From: Maria Tomalova
Sent: Friday, February 18, 2022 3:58 PM
To: Peter Cleveland [REDACTED]
Subject: FW: Stakers Farm

From: Maria Tomalova
Sent: 16 February 2022 13:58
To: Martyn White <Martyn.White@arun.gov.uk>
Subject: Stakers Farm

BARNs 1&2 PROPOSED SOUTH EAST ELEVATION
SHOWING SHUTTERS OPEN

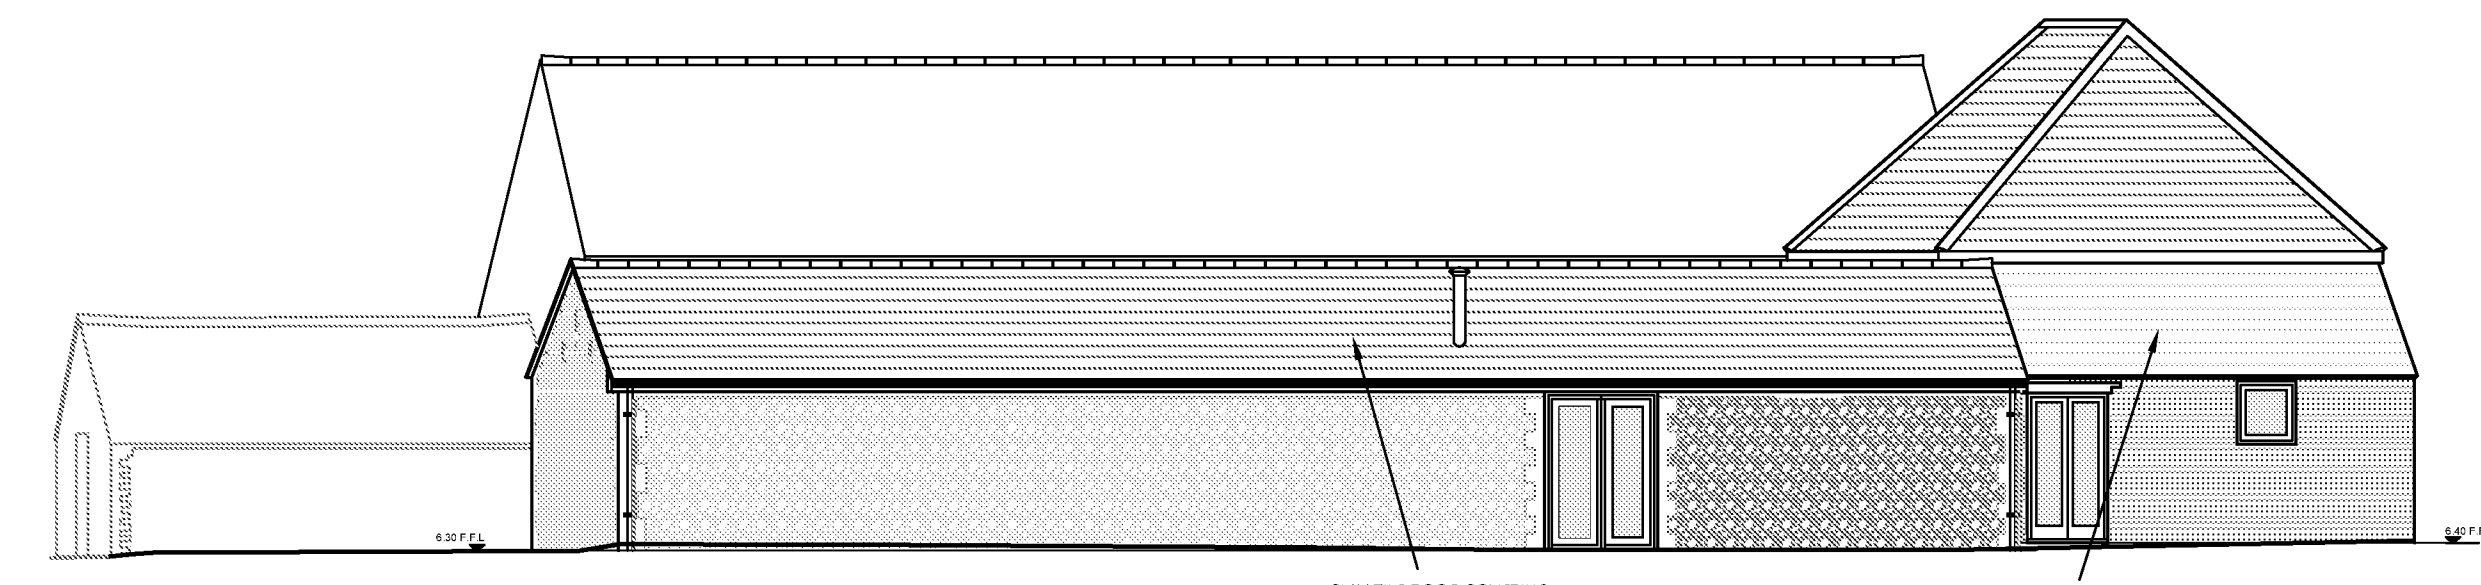
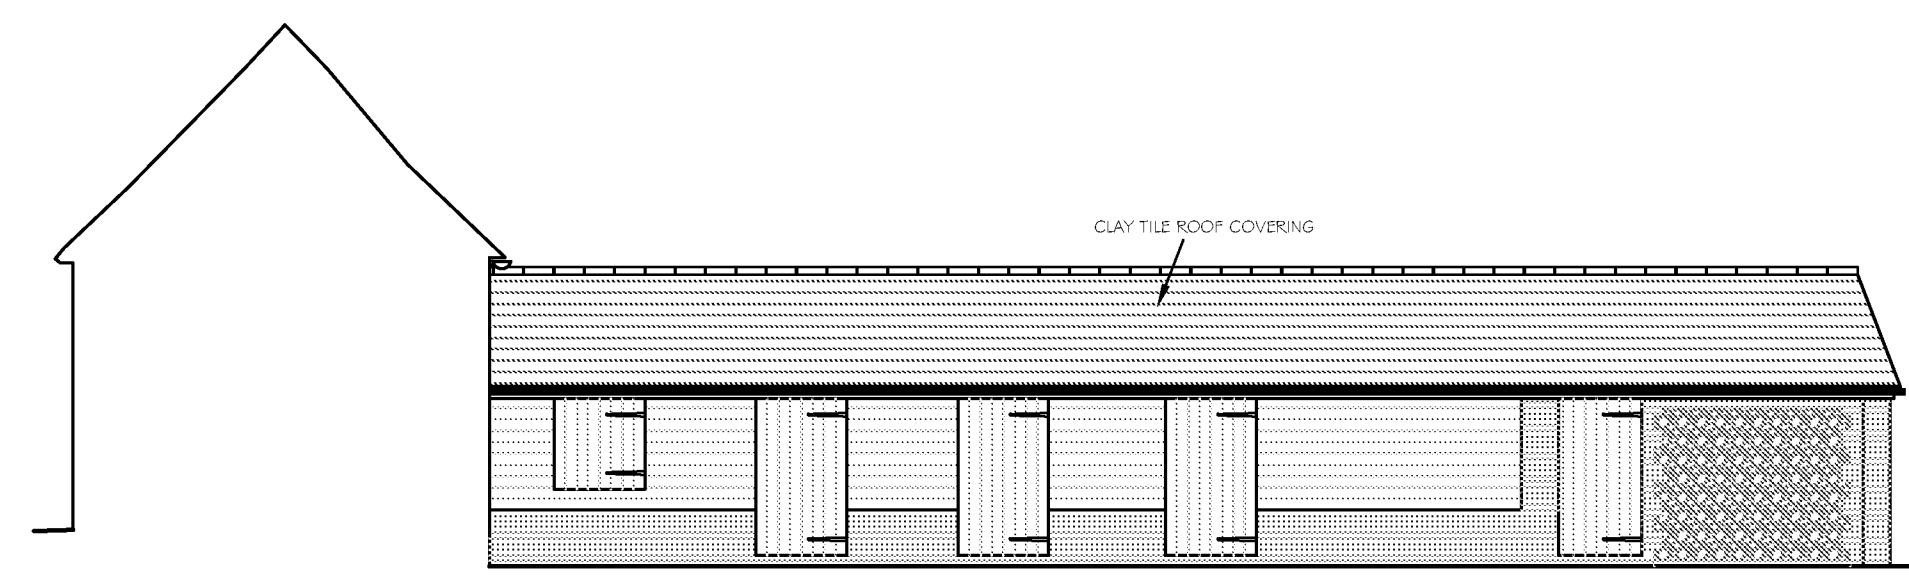
All the horizontal divisions should be back in the position where they were in approved plans and the same position should be maintain within all fenestration facing to the yard. The same apply for the largest opening. The replacement of the existing door (not original) as proposed is not acceptable and it would be helpful to discuss the replacement. There some other thing that should be clarified.

I do not understand, why they are showing bricks on this elevation to the right from the last opening; if you look at photo attached 1016 it shows flint.
